Comments for Planning Application 21/00264/CEU

Application Number: 21/00264/CEU

Address: Madina Mosque 2 Stanley Road Oxford OX4 1QZ

Proposal: Application to certify that the existing single storey outbuilding is lawful development.

PROPOSED EXTENSION TO EXISTING WASH ROOM AT REAR OF
 SCALE 1:50 2 STANLEY ROAD MOSQUE OXFORD

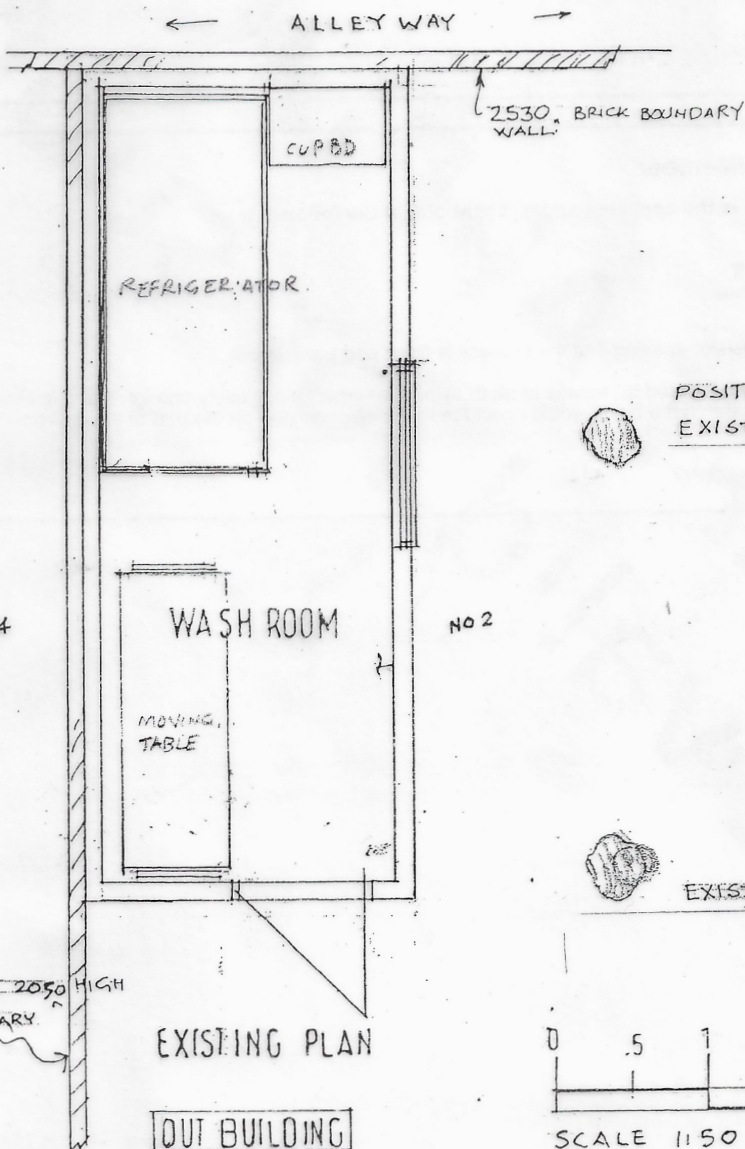
CONSTRUCTION NOTE the drawings in this and the previous application 20/02813/FUL are

contradictory and ambiguous. In fact, the mortuary would seem to have only 3 (maybe 2) substantial, supporting walls, being propped up against the neighbour's brick wall (and possibly the rear lane wall).

Its roof is suspended on and overhangs the no 4 brick wall which extends all the way to the roof not half way as shown in the drawings.
